**Pick n Payless Metal Recovery and Recycling Facility (SSD-8375)
Response to Submissions**

PICK N PAYLESS METAL RECOVERY AND RECYCLING FACILITY (SSD-8375)
DEPARTMENT OF PLANNING, INDUSTRY AND ENVIRONMENT – KEY ISSUES

Plan No. CC160136TR01

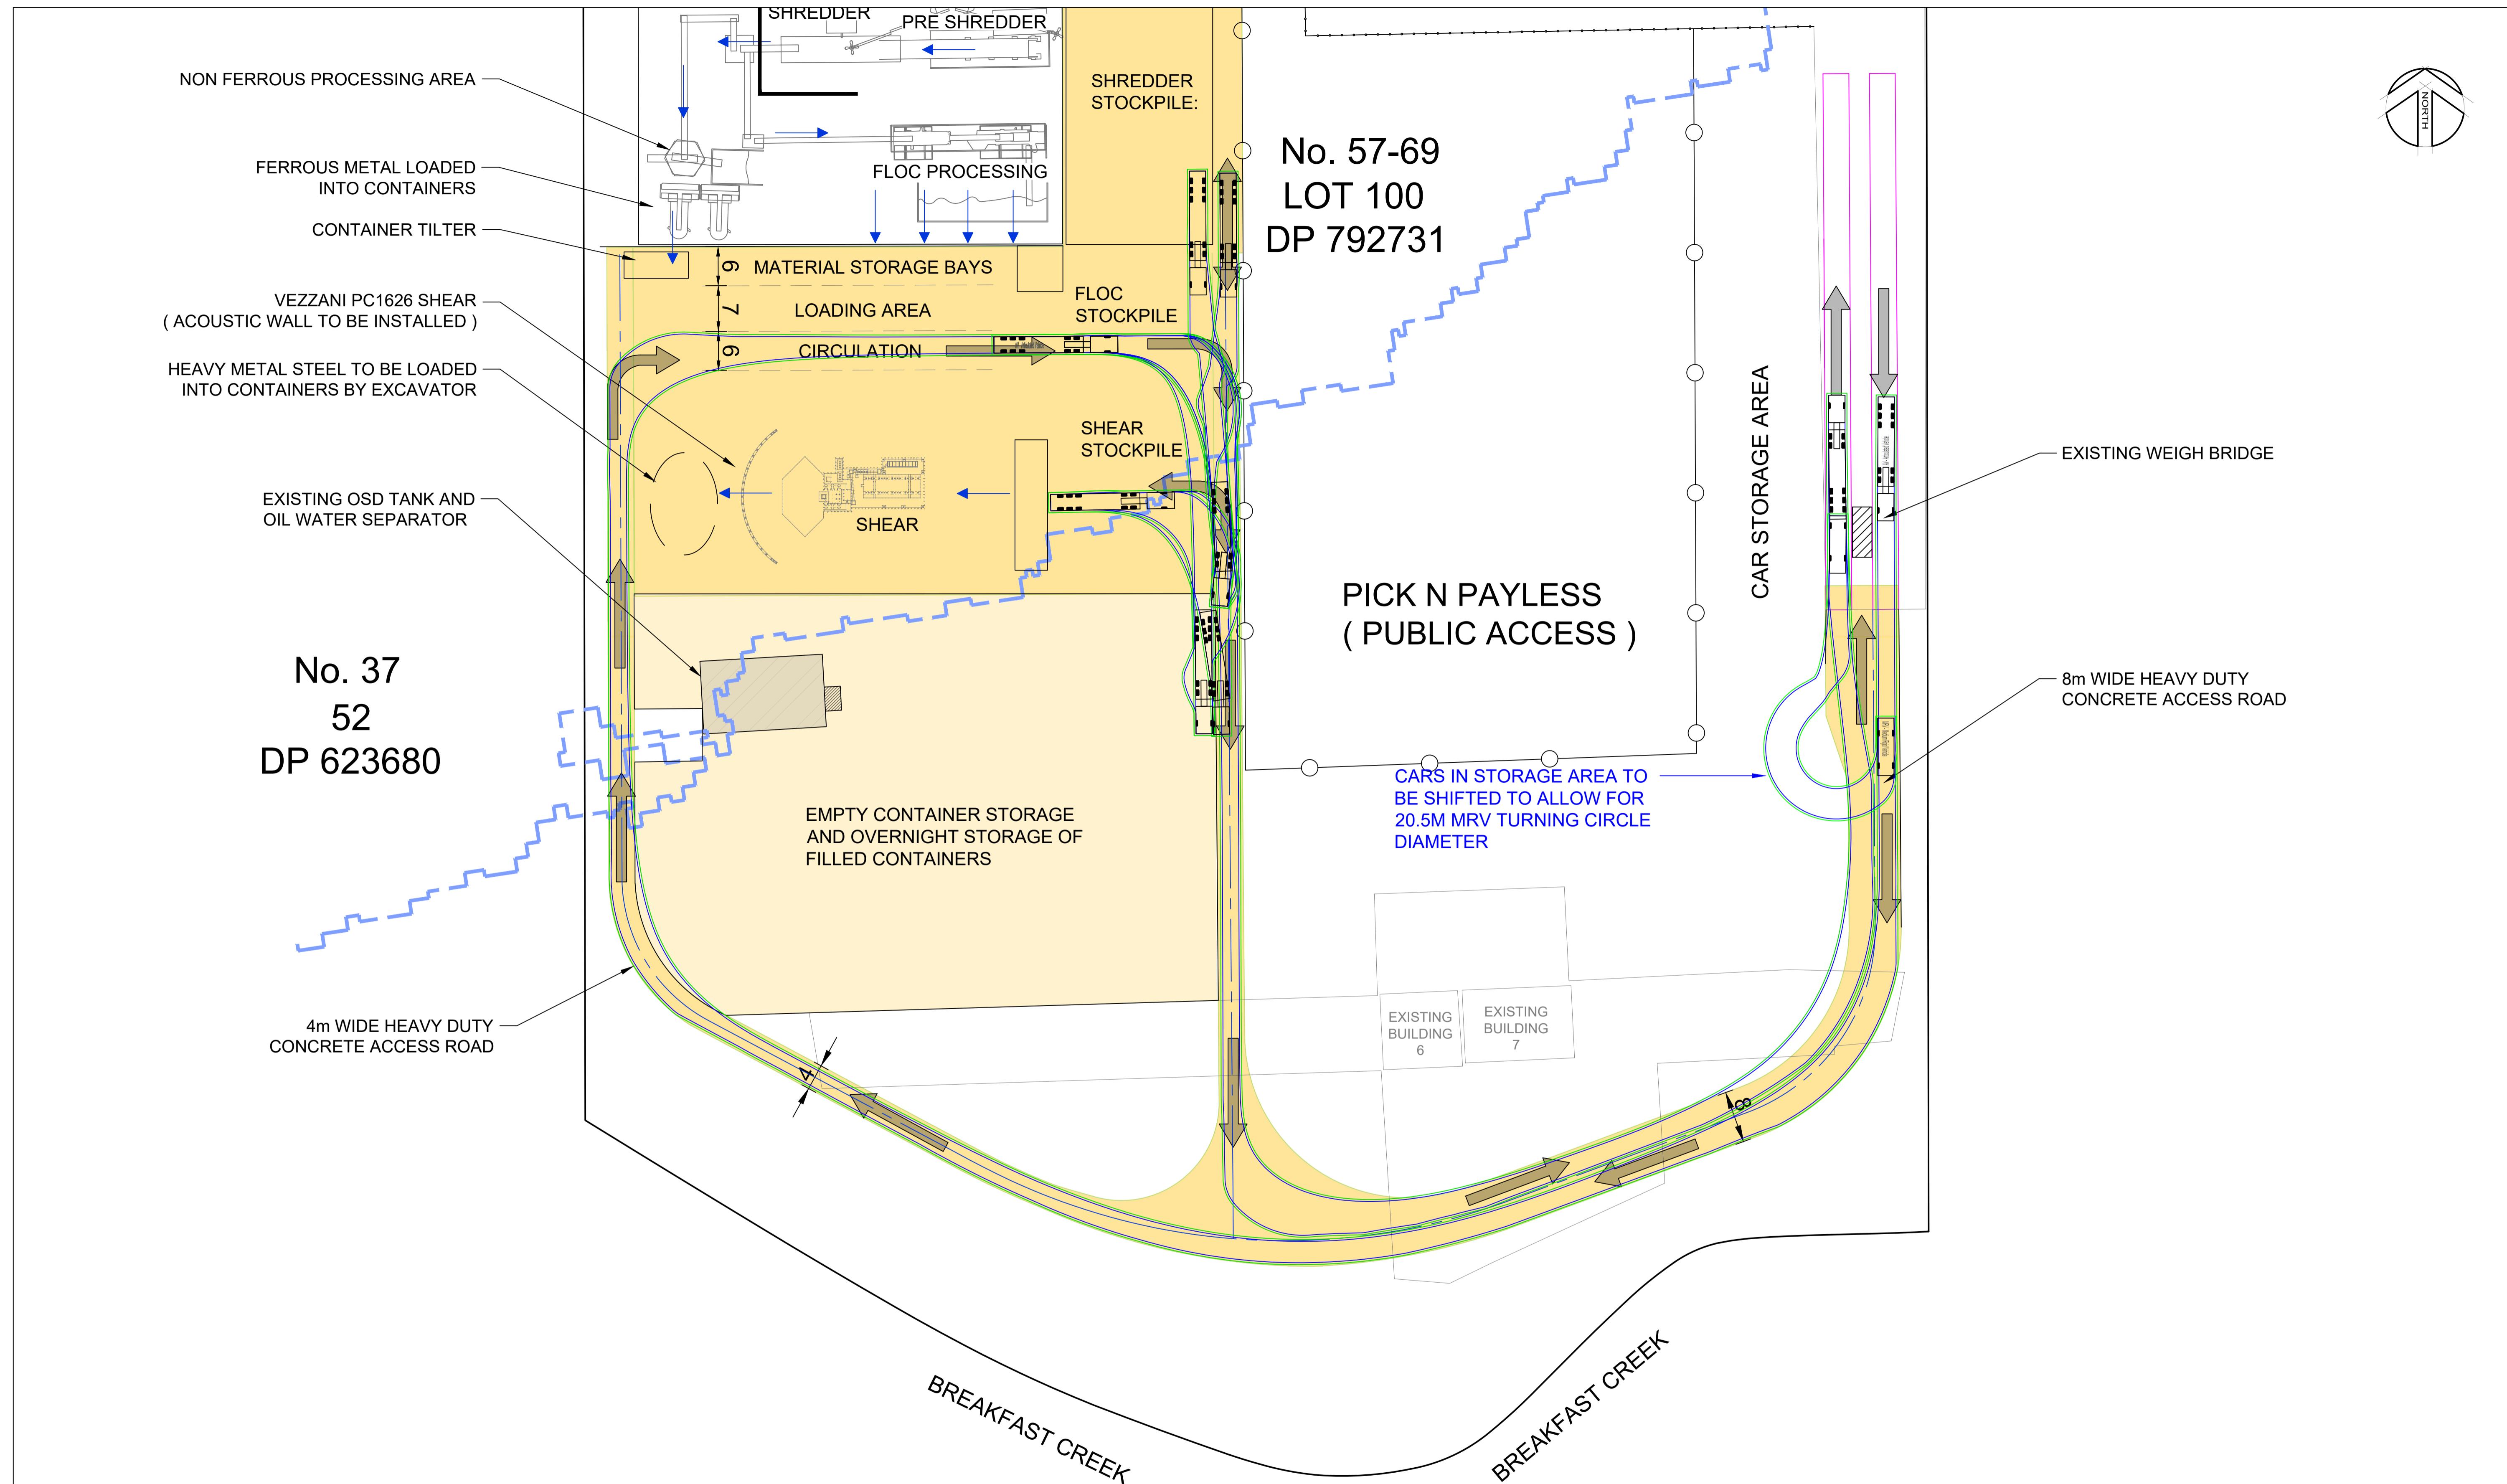
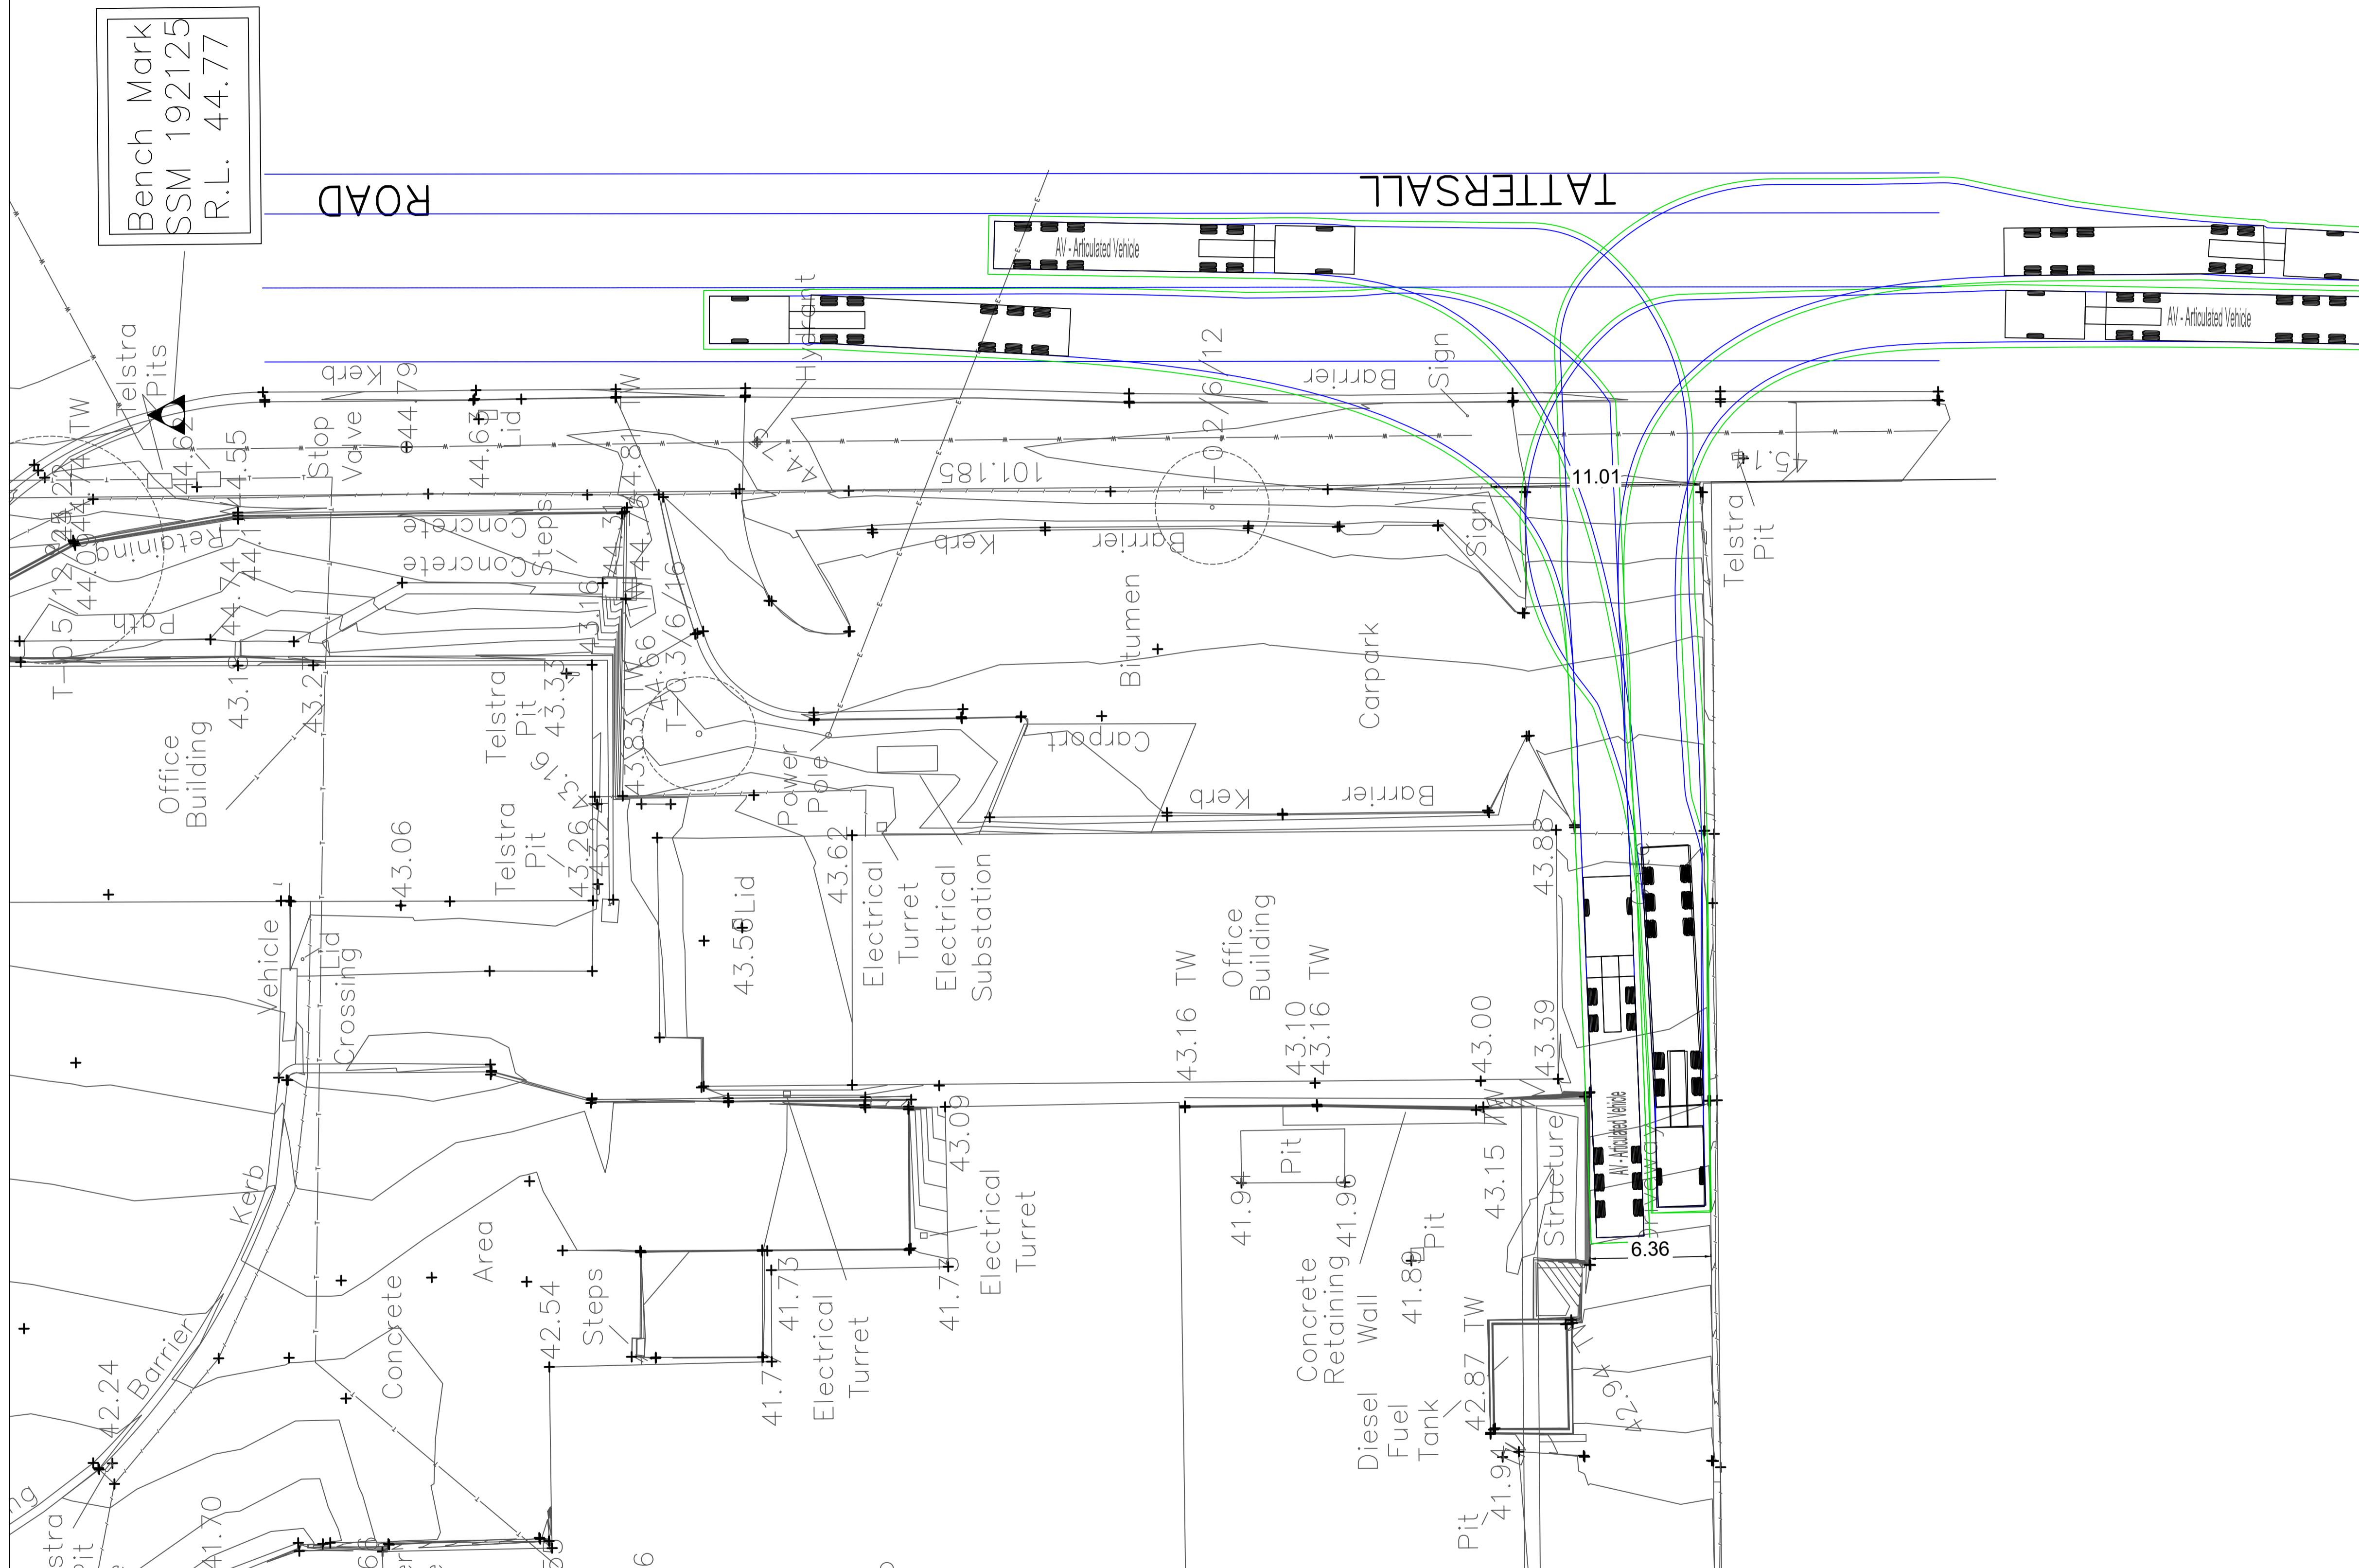
18. The Appendix B Swept Path Analysis of the TIA shows the proposed heavy-duty concrete access road is 4 m wide. This is inconsistent with the Site Master Plan and Fire Engineering Brief which show the proposed access road is 6 m wide. Please clarify the proposed width of the access road.
